From: Sarah Burrow
Sent: 20 March 2020 11:54
To: Planning.Responses
Cc: Simon Davis
Subject: RE: Planning Consultation on: Y/18/20/PL

Engineers Comments Regarding Surface Water Drainage

APPLICATION NO: Y/18/20/PL

Site Address: Land east of North End Road & West of Church Lane Nursery
Yapton

Drawing Title		Engineering Details	
Construction Details			
Drawn	Checked	Scales	Page Size
KN	KN	AS 3100M	A1
Job No.	Issued By	Issued By	Date
KNC2004	501-01	501-01	10.12.01
Revision	A

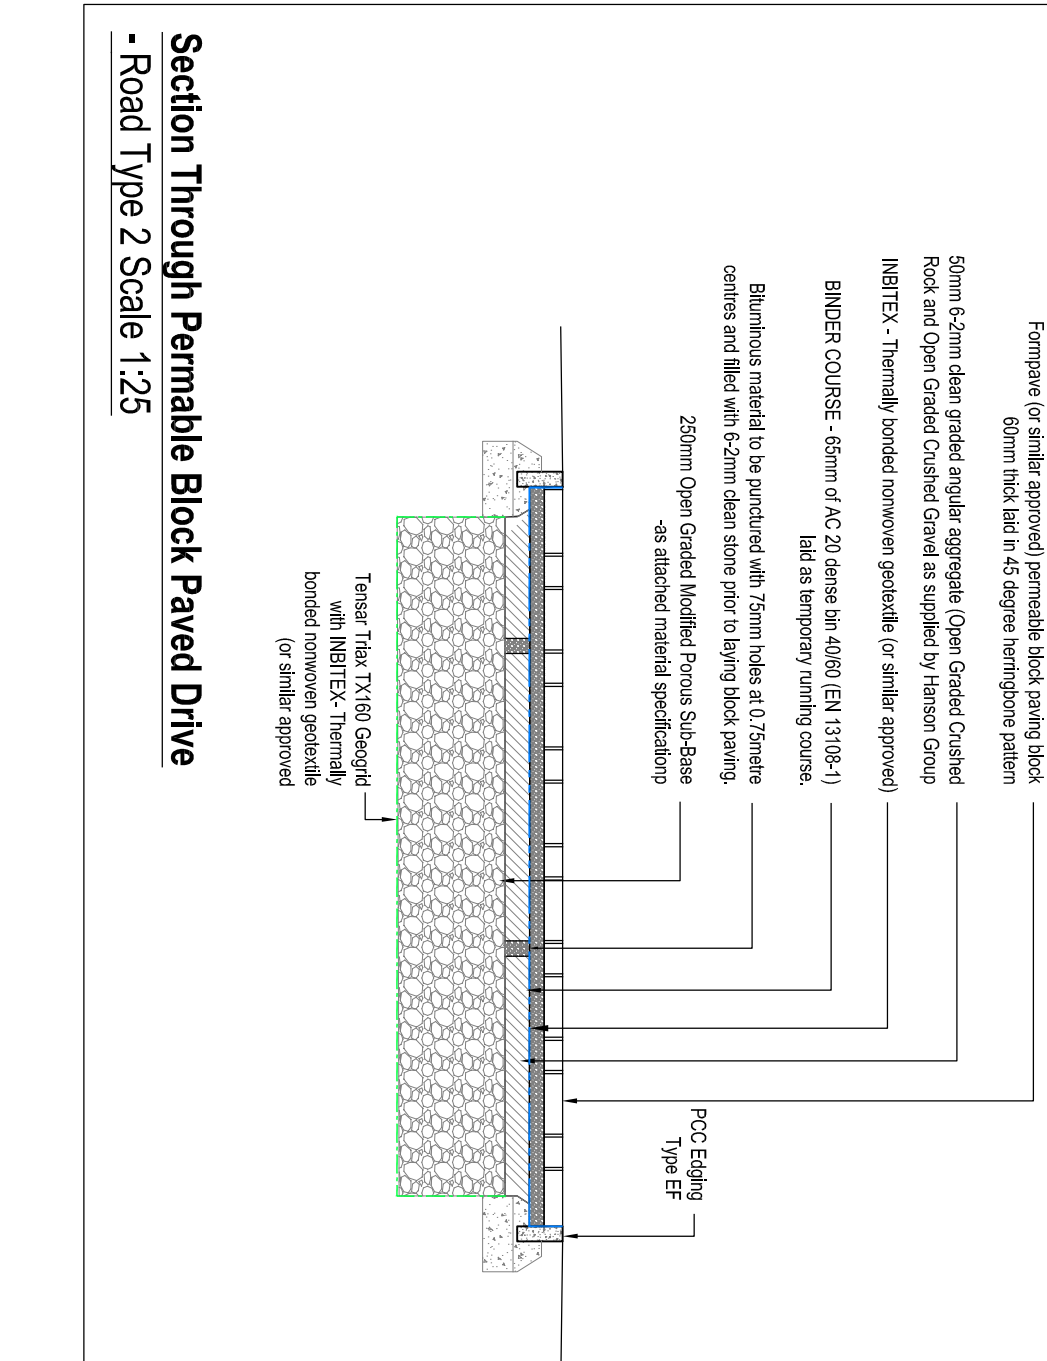
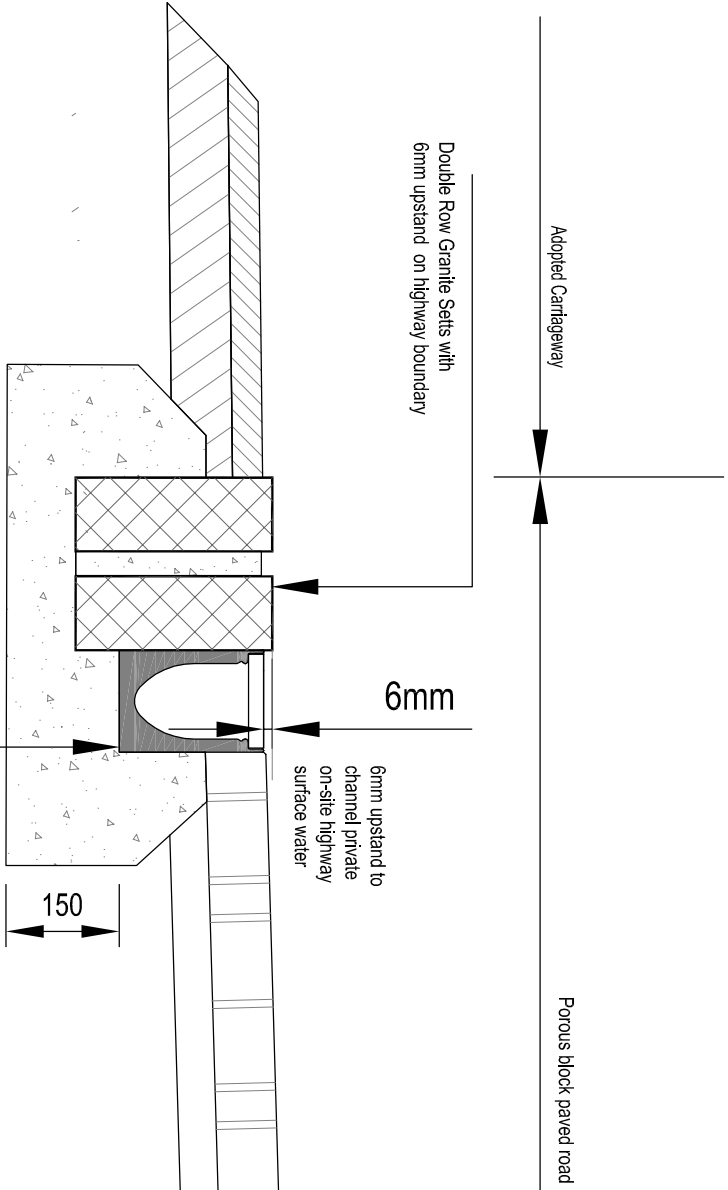
6. Why is the porosity different for the two access road calculations?
7. I am not convinced by the depth of 1.64m for the Access Road (0-40m chainage). Long section Road 1

8. I echo Laura's comments on the neighbouring application; please confirm weep holes will be included in the retaining walls at the access road.
9. Please include a construction detail drawing for the Aquacell soakaways.
